ENG-SF20015-R1-GEC.pdf Markup Summary

SF-20-015

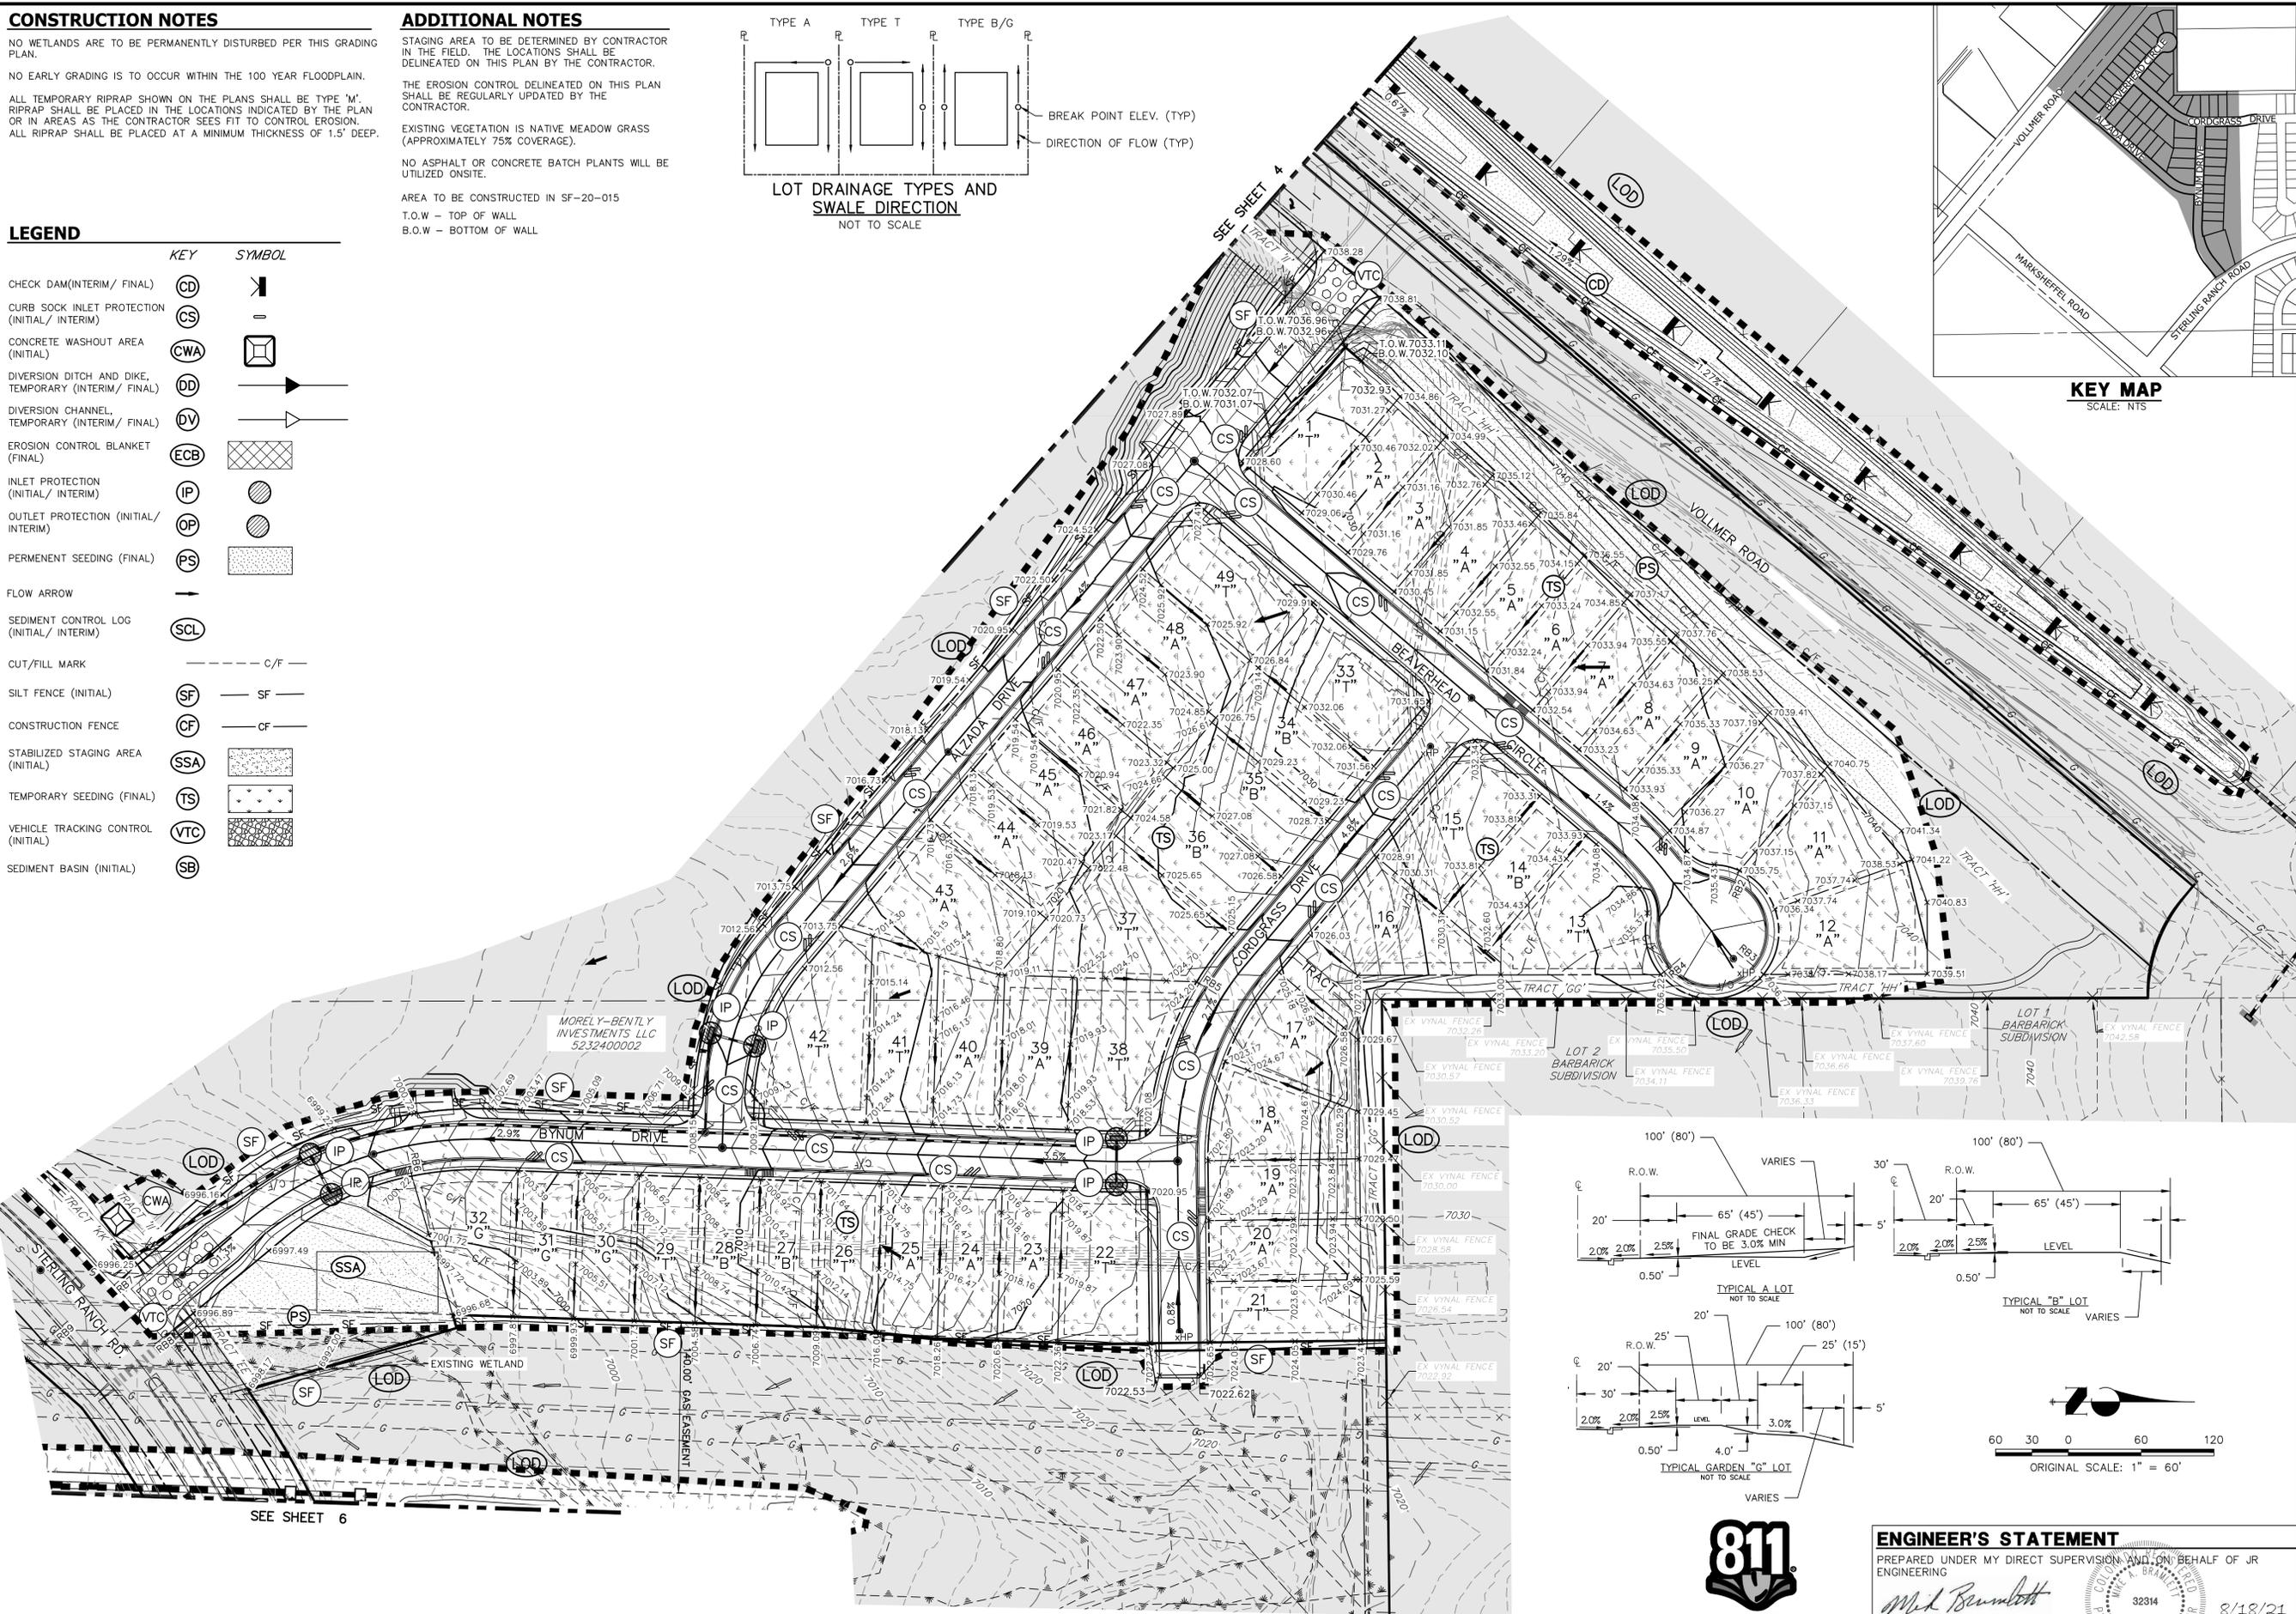
adjust label

Label EOP, shoulder, etc.

?

label

Move the CWA to the other side of the road, away from wetlands / drainage

show and label wetlands

Provide temporary cul-de-sac

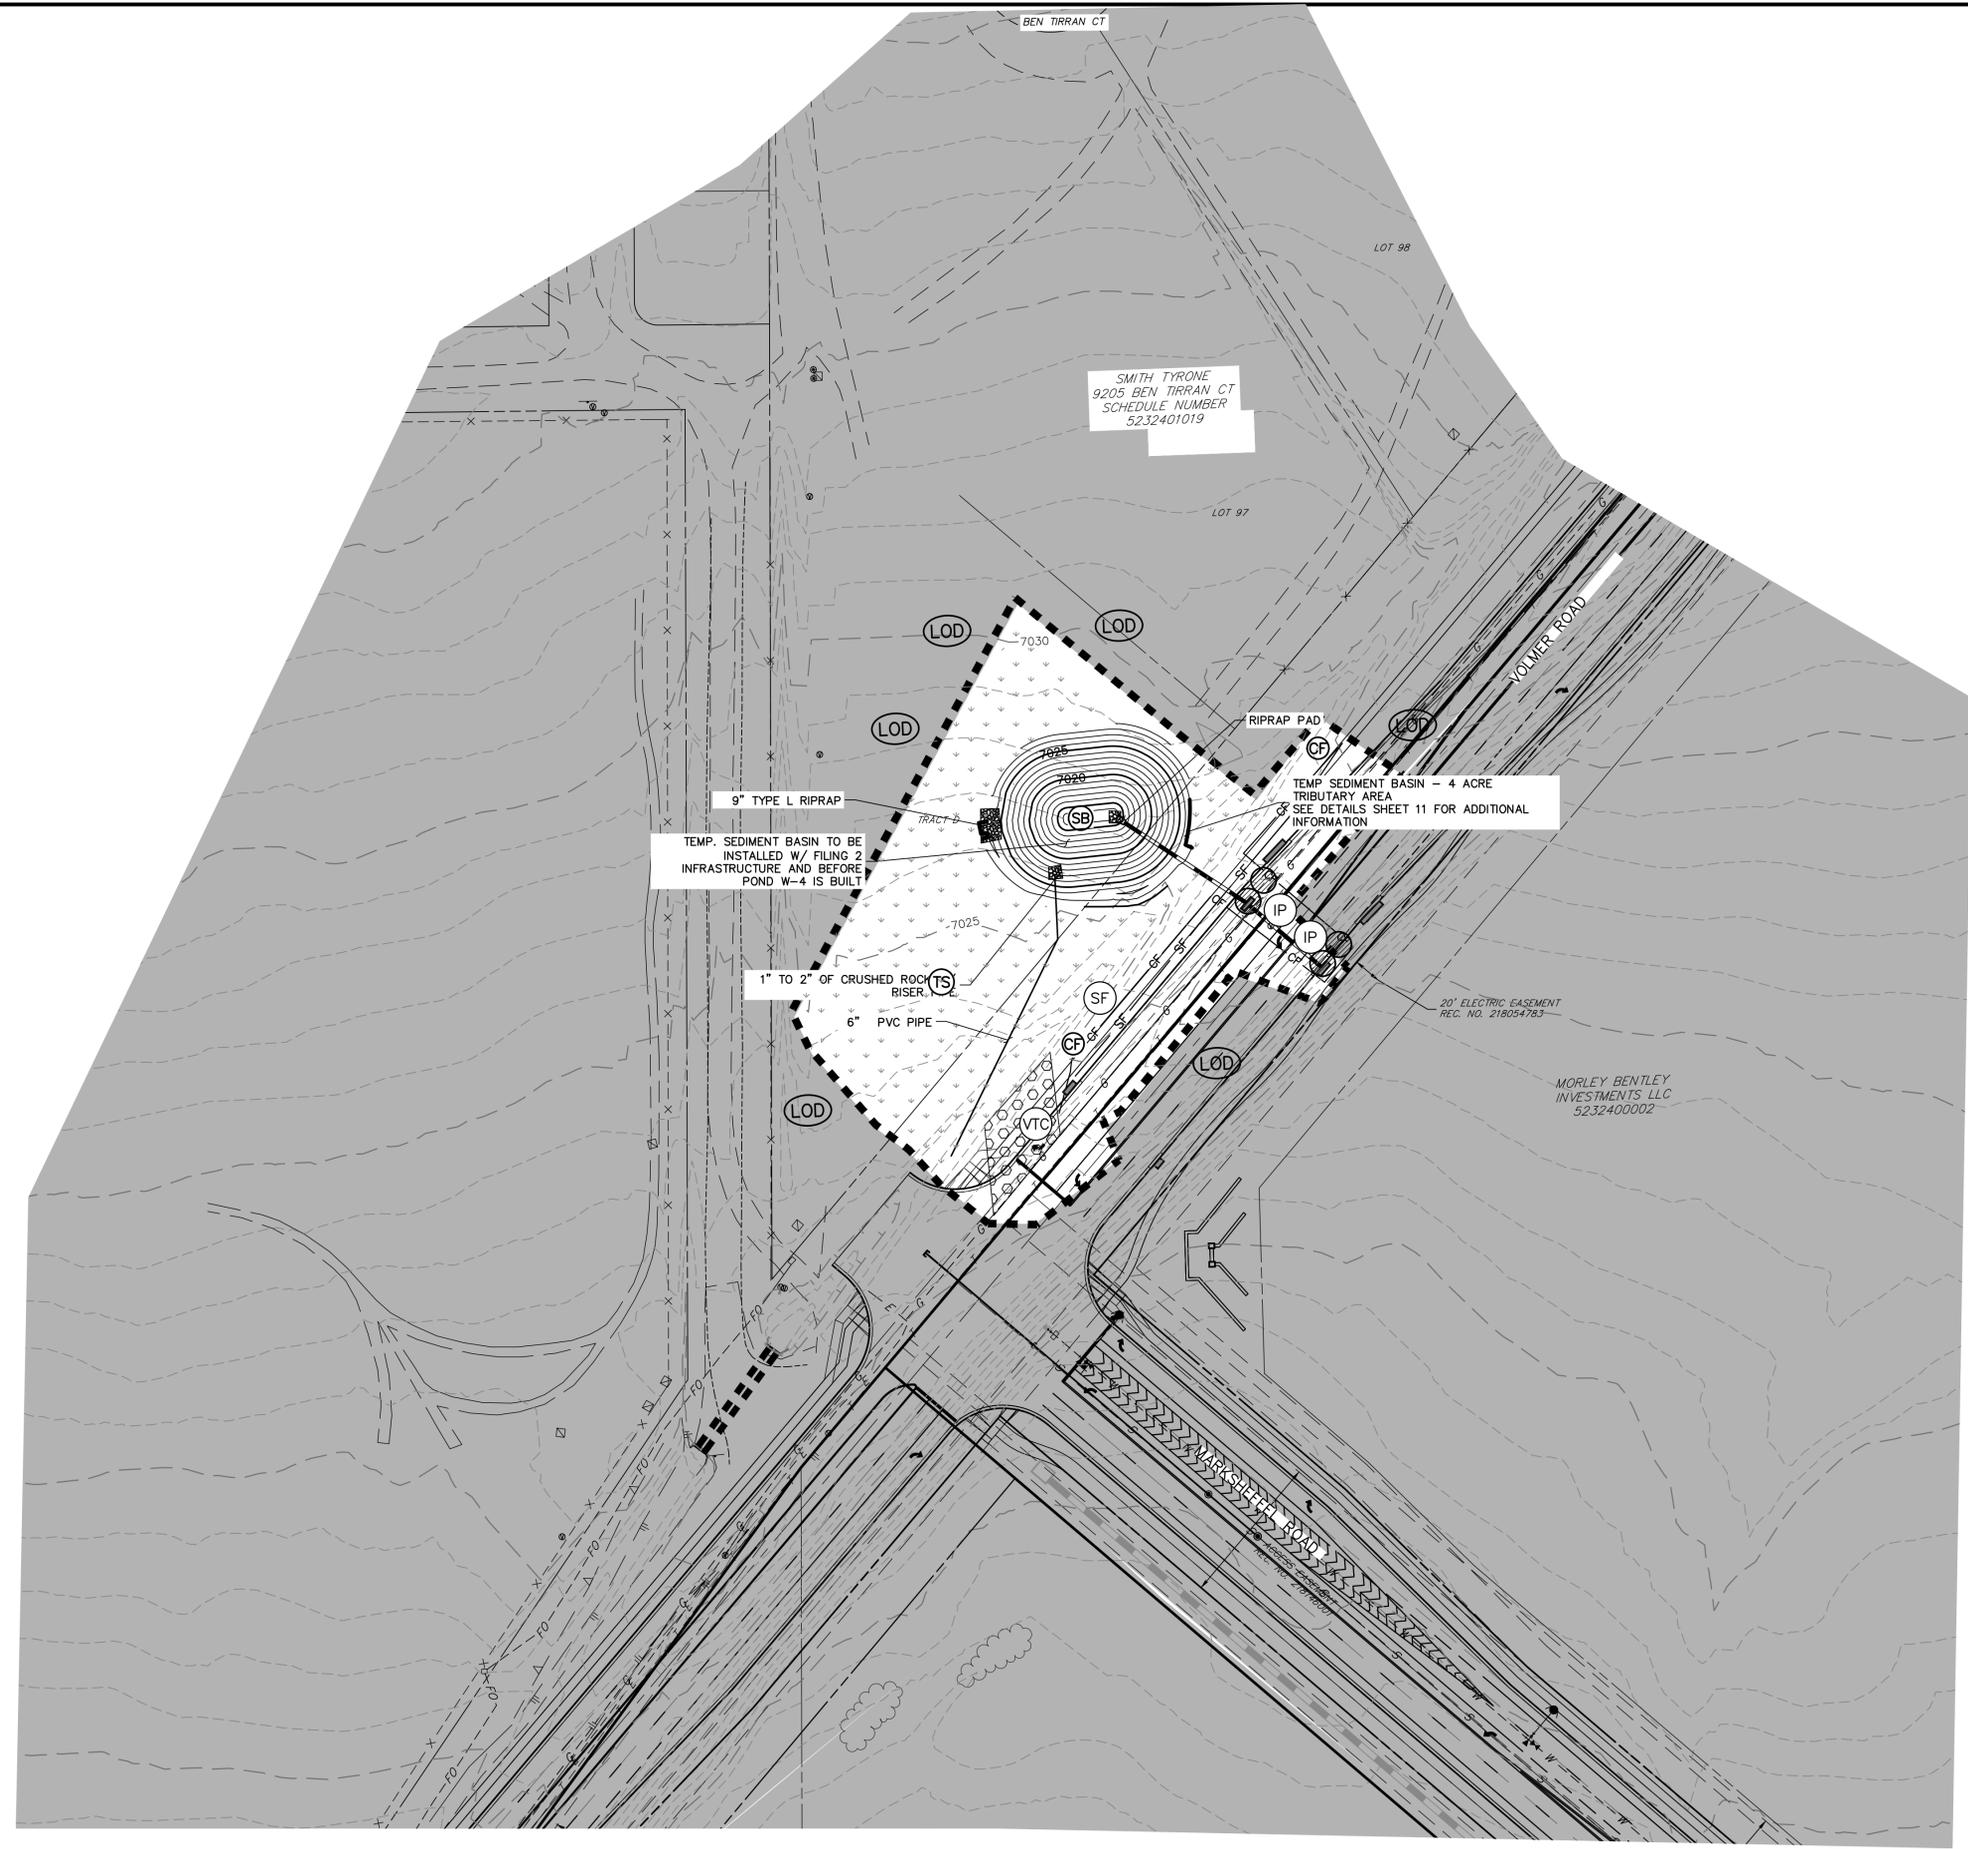
This pond needs to be constructed prior to Vollmer Road improvements

Show future ROW

Provide another inlet for the spillway tying into the outfall pipe.

Provide a plan and profile for this channel

Clearly delineate the maintenance access roads from the west and/or north, not Marksheffel or Vollmer

CWA should be away from the ditch

Show grading and relocate culvert for the interim Tahiti Dr. realignment.

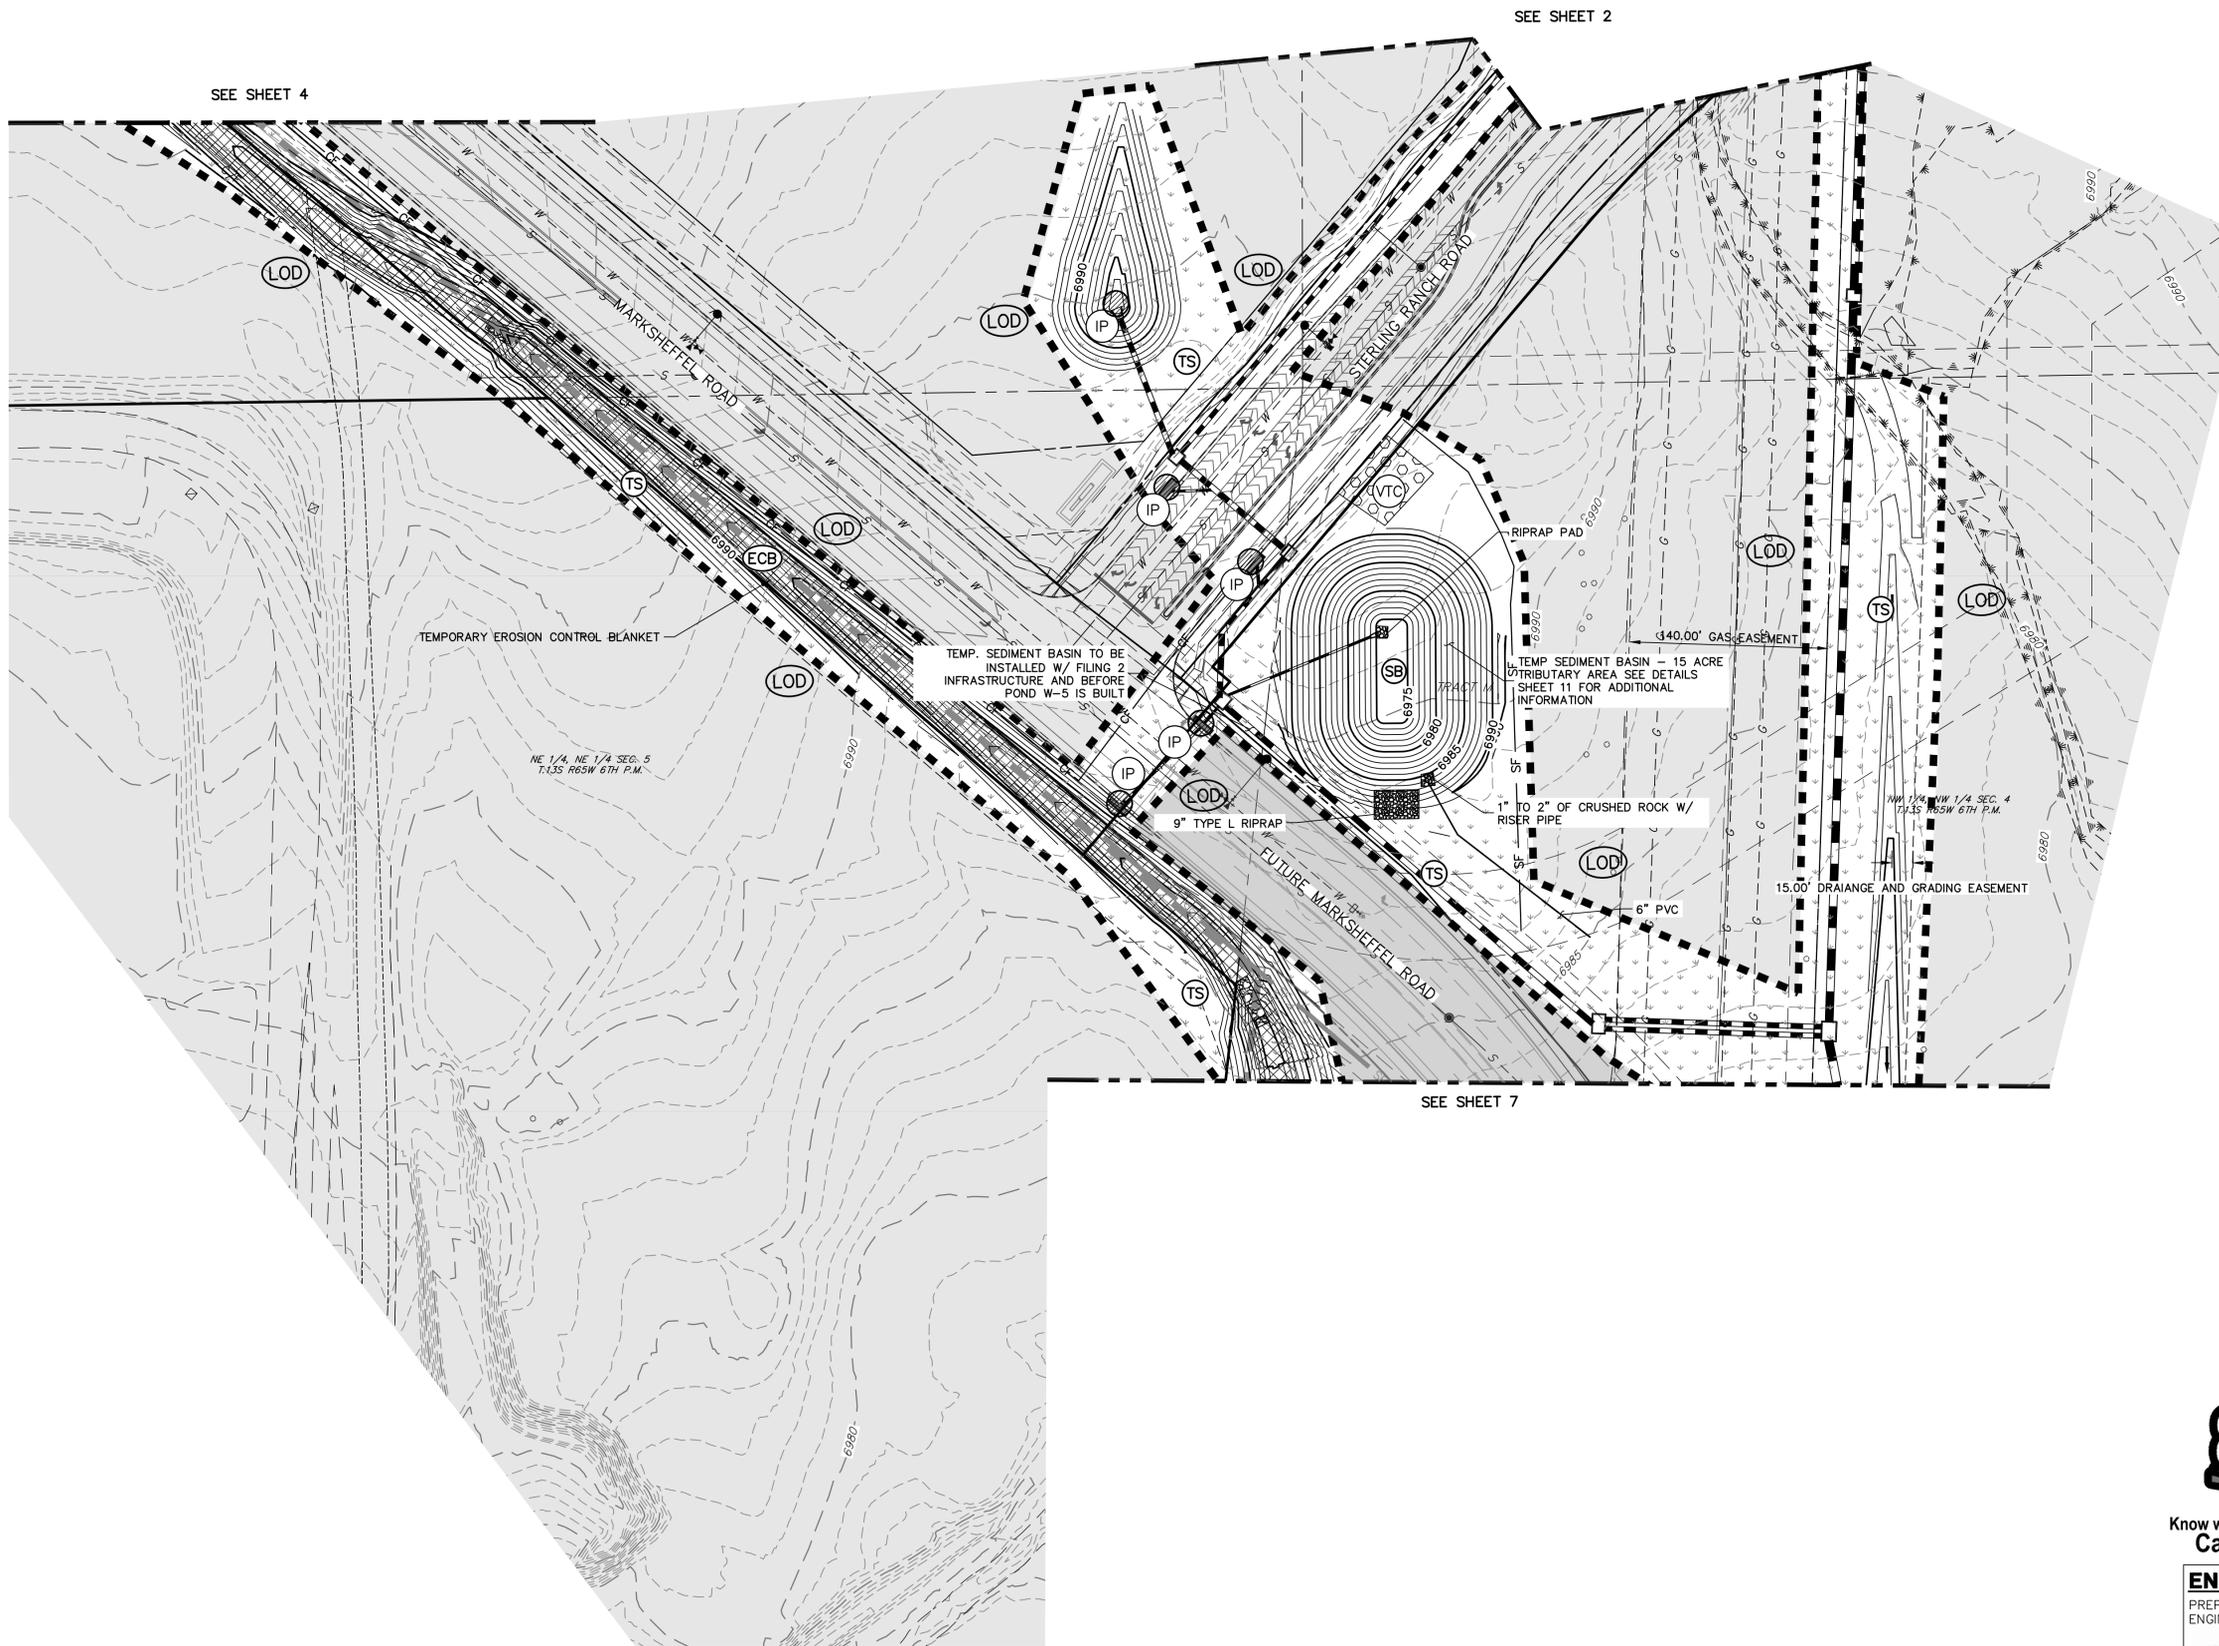
Is this grading existing?
